Appeal Decision

Appeal Ref: APP/A2525/W/19/3227640

The Fitness Company, 38 Spring Gardens, Spalding PE11 2XL

- The appeal is made under section 78 of the Town and Country Planning Act 1990 against a refusal to grant planning permission.
 - The appeal is made by Minster Building Company against the decision of South Holland District Council.
 - The application Ref H16-0469-18, dated 14 May 2018, was refused by notice dated 20 March 2019.
 - The development proposed is described as the 'change of use of the existing building from use class D2 to use class C3, to include one 1-Bedroom apartment and eight 2-Bedroom apartments, proposed new four storey apartment building including twelve 1-Bedroom apartments, and associated external works and infrastructure.
-

Drawing Title:
**Proposed New Apartments
Roof Plan & Elevations**

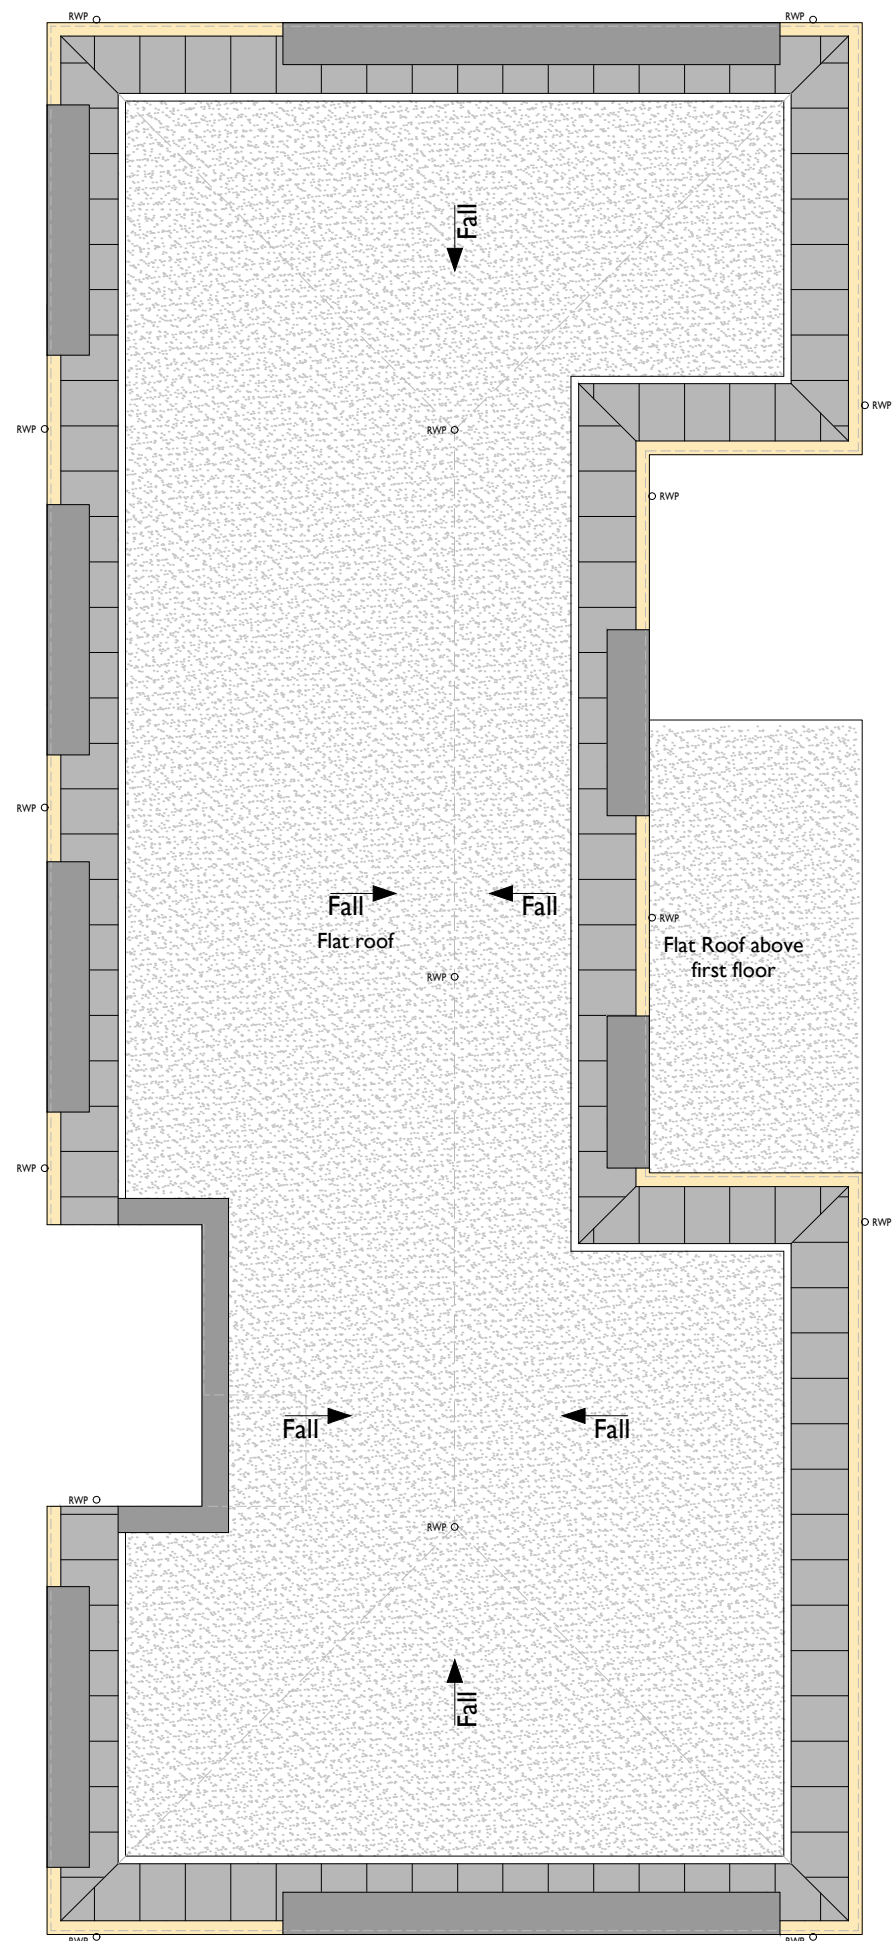
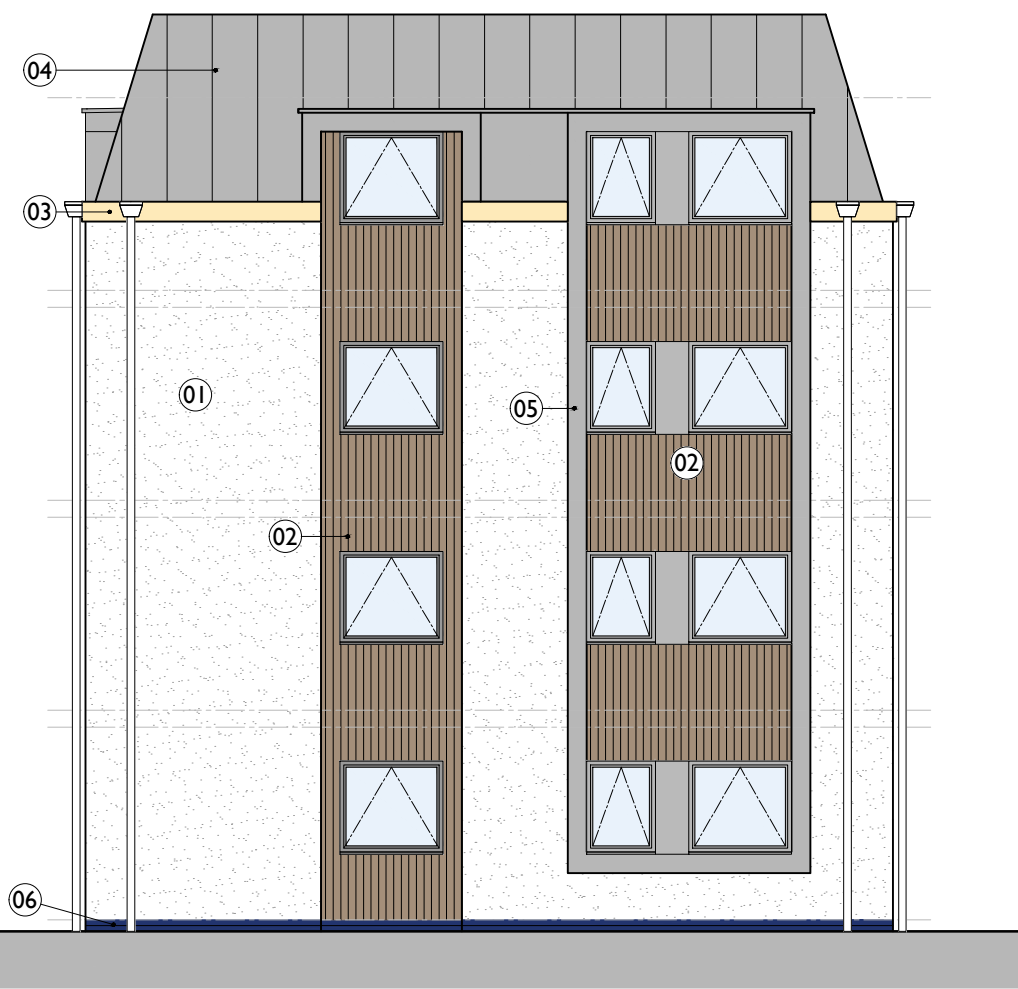
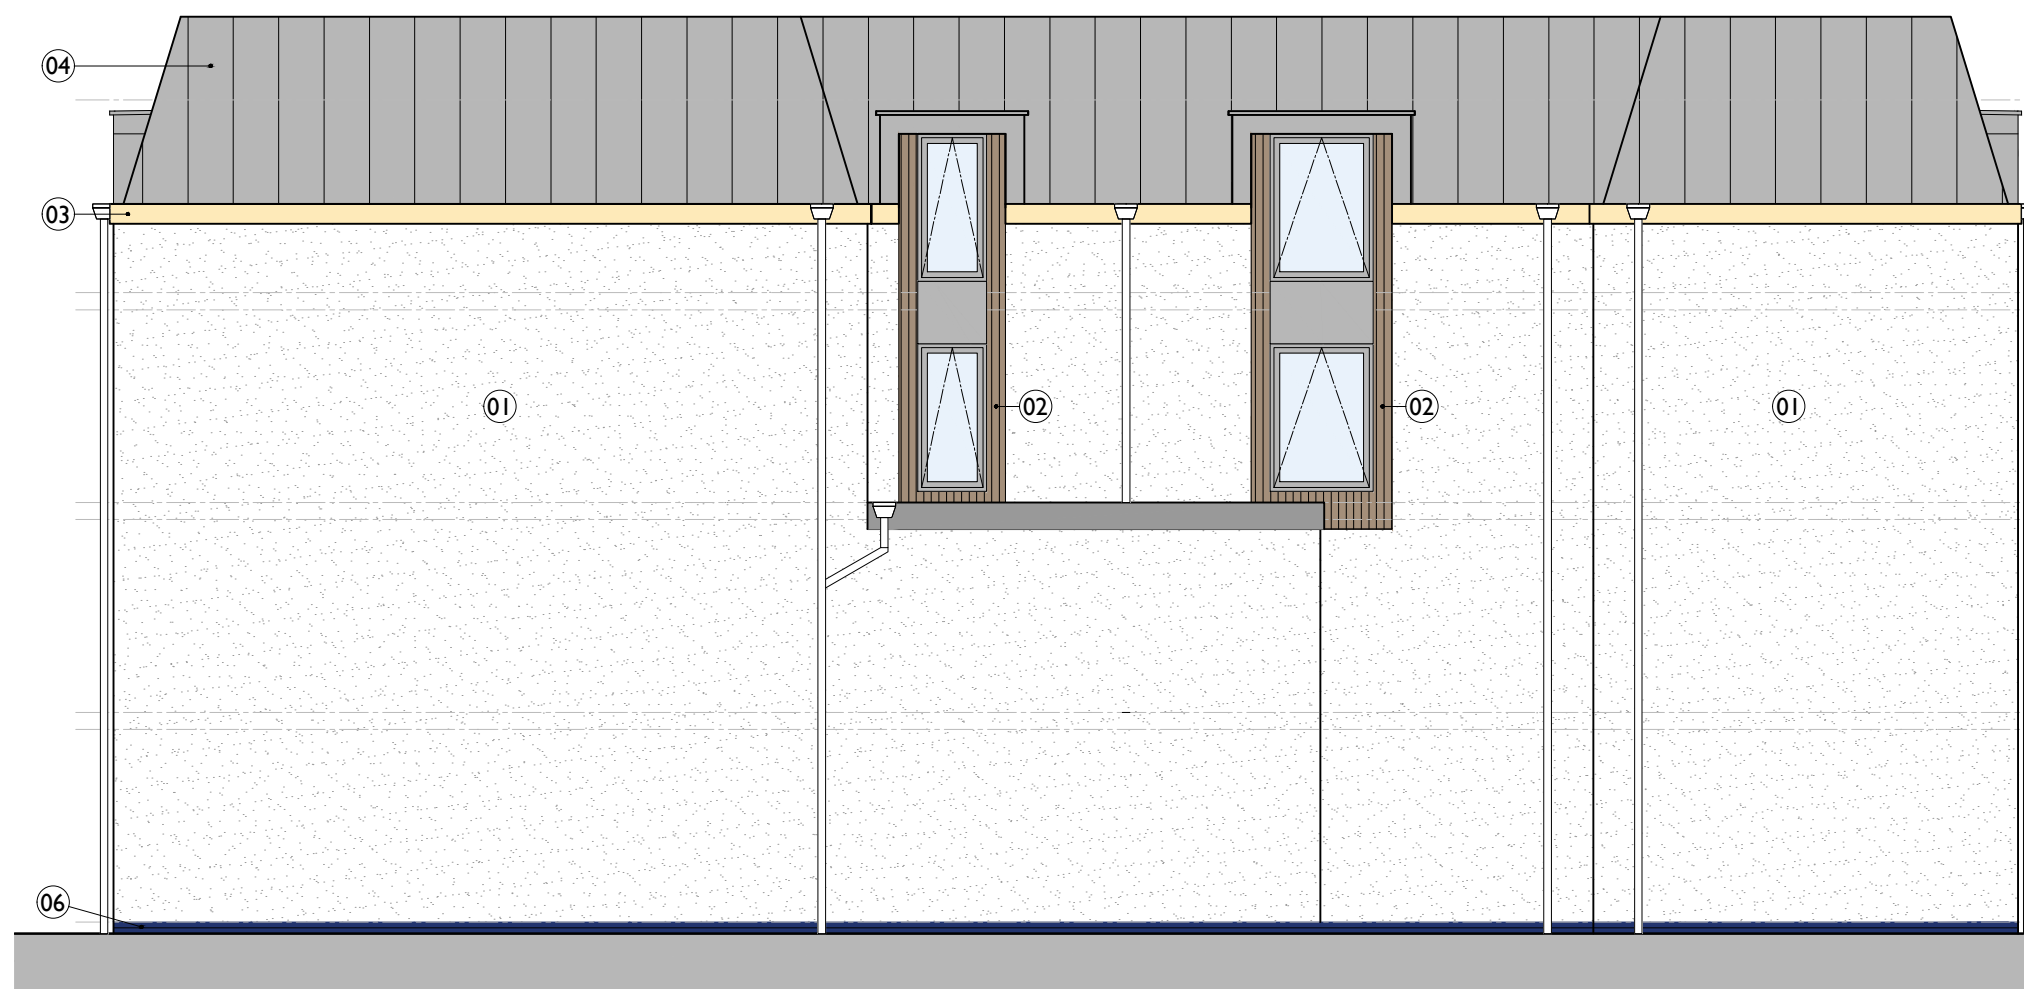
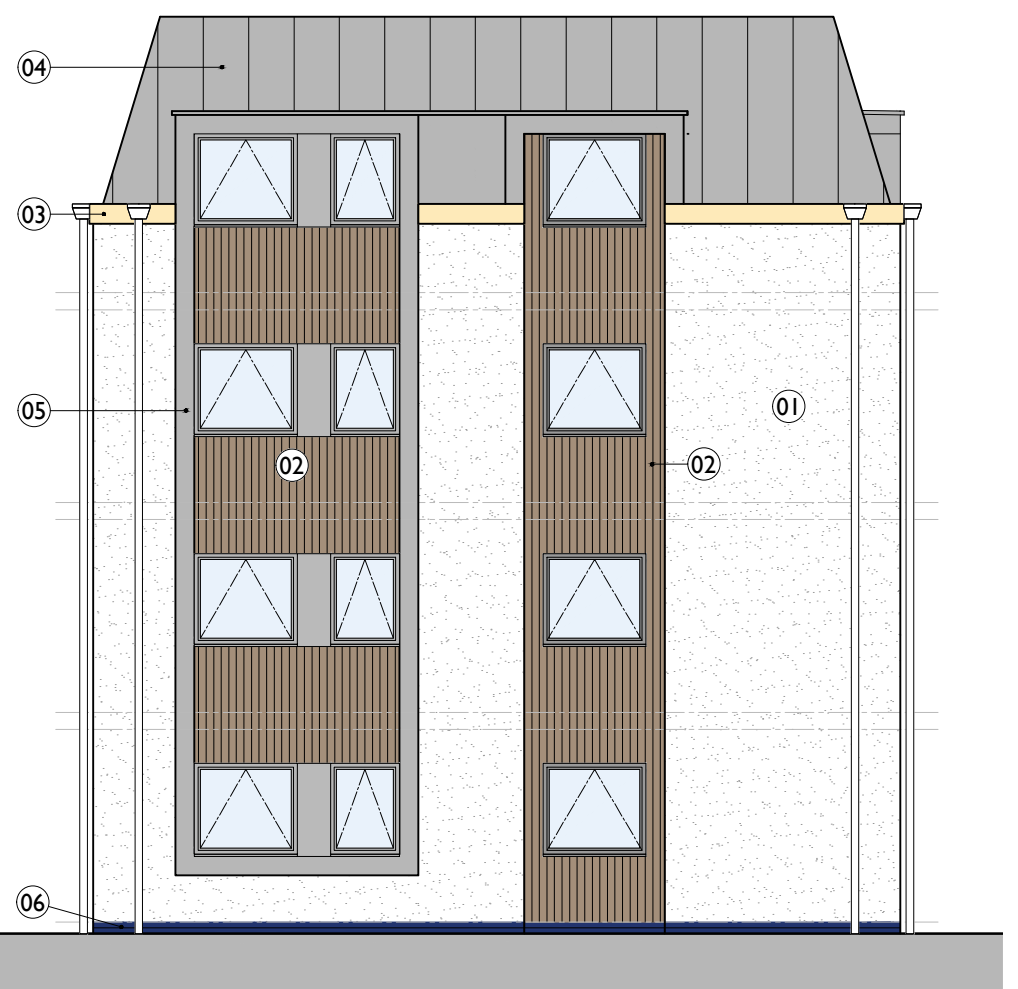
13. The new proposed building would be roughly rectangular in plan form and would be of a width similar to the former Christian Association. The building would have a mansard to a flat roof and would be predominantly faced in dark toned brickwork with cedar cladding between the windows, which would be regimented in their form and rhythm. Zinc cladding would cover the mansard and windows surrounds. The height of the building as shown on the plans would be virtually the same as the former Christian Association, and higher than the adjacent former depot, and would be sited on the plot closer to the latter building than the listed building but further forward than the heritage asset.

14. The former Christian association is a striking building, noted in the listing as being 'visually arresting'. As such, the building draws the eye and makes the passer-by look up and appreciate the details and architectural composition of the structure. The height and extent of the proposal would detract from this impression; while the height may seem very similar from the plans this is the height of what is effectively a flat roofed building with only a small false hip. The Appellant's Design and Access statement notes that the new building would be subservient to the existing building as this would be lower than the height of the square tower entrance bay. However, visually the height of this tower appears very similar to the pinnacle of the eastern gable, set closest to the proposed new building.

15. The bulk of the building would appear 'weightier' than the listed building whose roofline is varied and interesting and would draw the eye away from the former Christian association in a negative way. The building would not be subservient to the listed building and the proposed striking materials, including dark brick and uncharacteristic (to the area) timber cladding would accentuate such an effect. Such an effect would be noticeable from Spring Gardens, as well as from viewpoints from the south on Priory Road. From further along Spring Gardens close to the junction with the Crescent, the siting of the proposed new build significantly further forward in the plot than the adjacent listed building would dominate views and have an significant adverse effect on the setting and the significance of the former Christian Association, appearing as an overdevelopment of the site, neither preserving nor enhancing the character or appearance of the SCA.
